Application No: K/11/22/PL
Site Address: Salamanda 37 Coastal Road Kingston BN16 1SJ
Description of works: Demolition and erection of 1 No detached dwelling. This site is in CIL Zone 4 and is CIL Liable as new dwelling.

Council objects to this application for the following reasons:

Proposed South Elevation

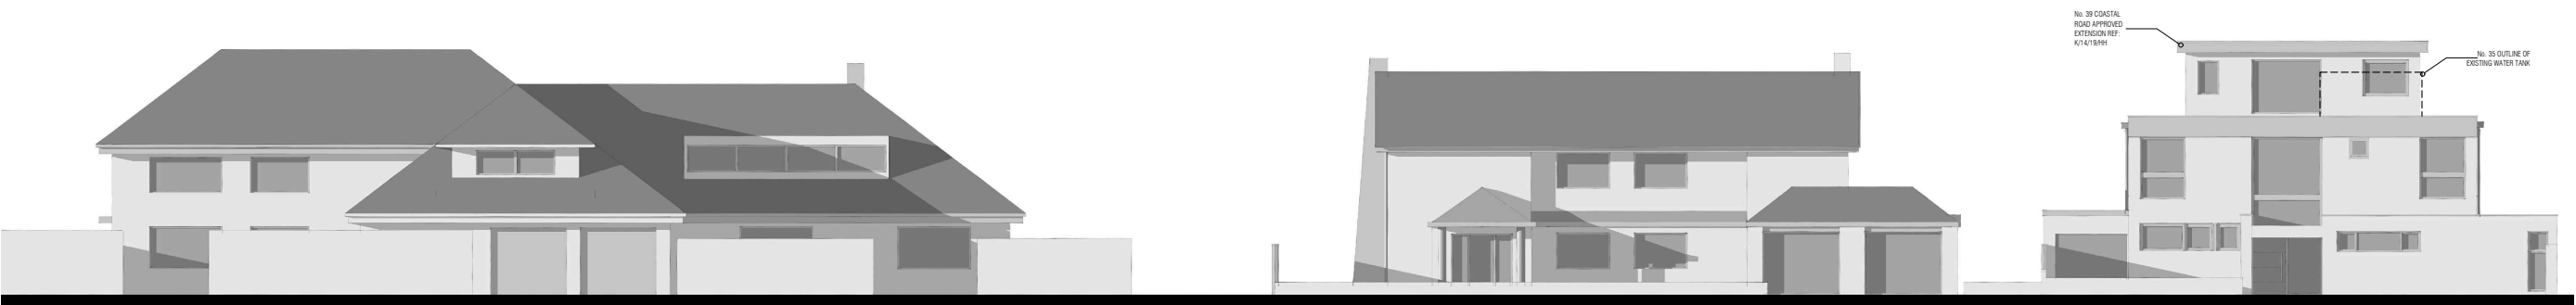
2. Council objects to the proposed open roof terrace that gives 360 degree views across the neighbourhood as:

- i) it is out of character and not of a suitable design for the neighbourhood and would set an unwelcome design precedent.
- ii) the street scene of Coastal Road and views from public footpath 2110 (the greensward) would be adversely affected.

- iii) there should be no increase in roof height. The new build should not be higher than the existing dwelling or neighbouring properties. The proposed half height panels appear to only take the level of the proposed new dwelling to that of the existing but the true height needs to take in to account the height when occupants are standing on the roof terrace.

- iv) it is intrusive to the privacy of nearby properties and the wider neighbourhood and therefore, there should be no access to the roof except for maintenance. Council notes the suggestion from a neighbour that there could be a privacy screen to head height but this would further impact on our objections regarding design and mean that the overall build height for the proposed dwelling would be higher than the existing dwelling and higher than the height of neighbouring properties and this would not be acceptable.

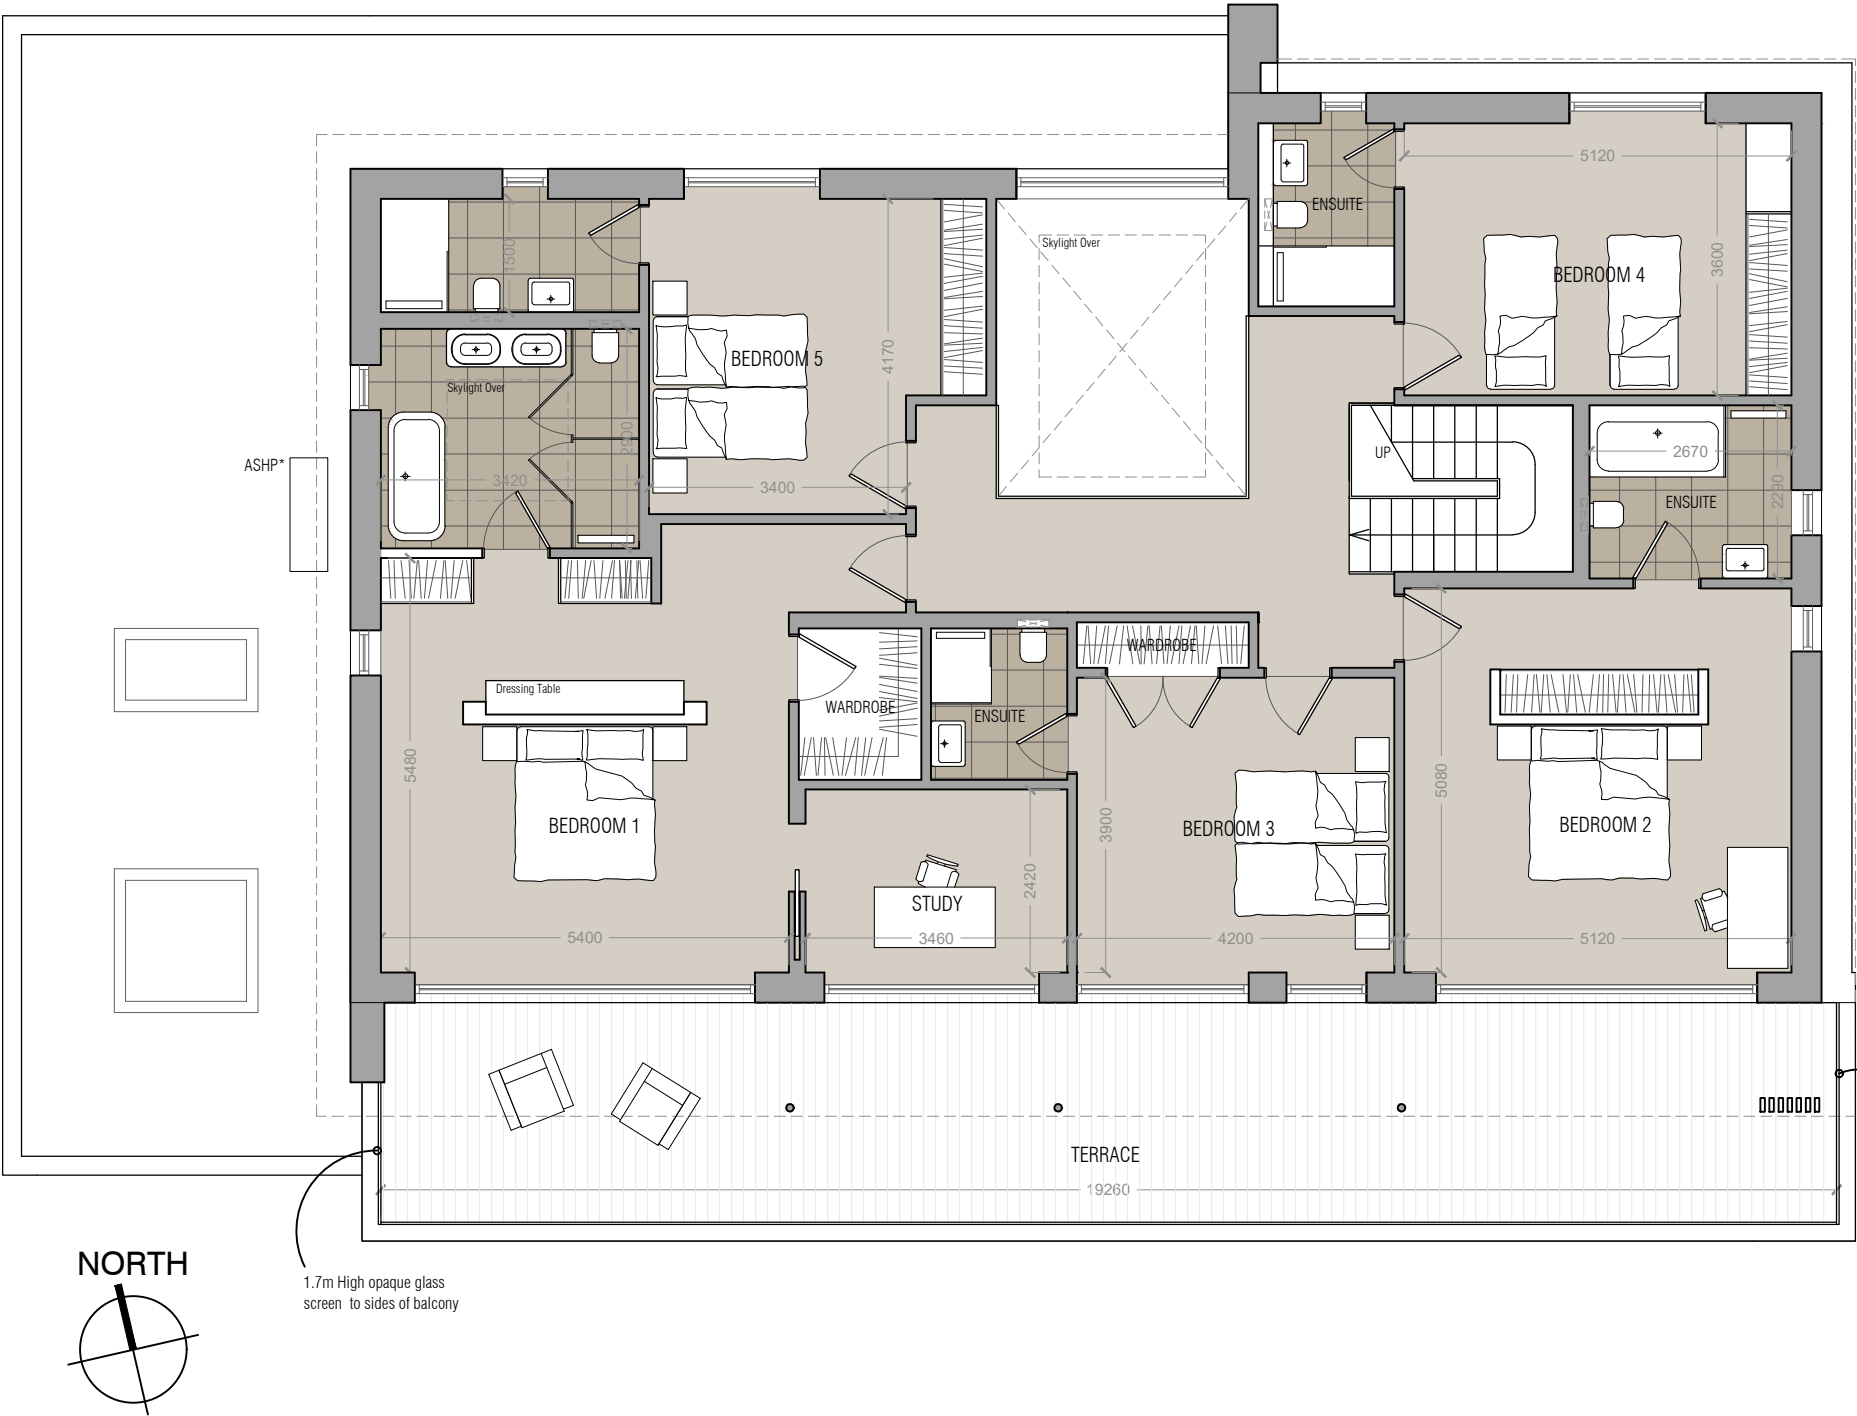
3. The first floor rear balcony is intrusive to the privacy of neighbouring properties unless privacy screens are included to the east and west ends of the balcony.

- i) that the pool plant is located close to the boundary and may cause a noise/vibration nuisance to the neighbouring property to the west.
- ii) there is an important drainage outfall pipe that runs adjacent to the eastern boundary of the property and the Arun drainage engineer should be consulted on this proposal to ensure the outfall pipe is not compromised.
- iii) Council understands that the ancient byway BOAT 3623 passes across some of the garden of this property and that this should not be built on. County Public Rights of Way legal section should be consulted on this to clarify the protected route of BOAT 3623.
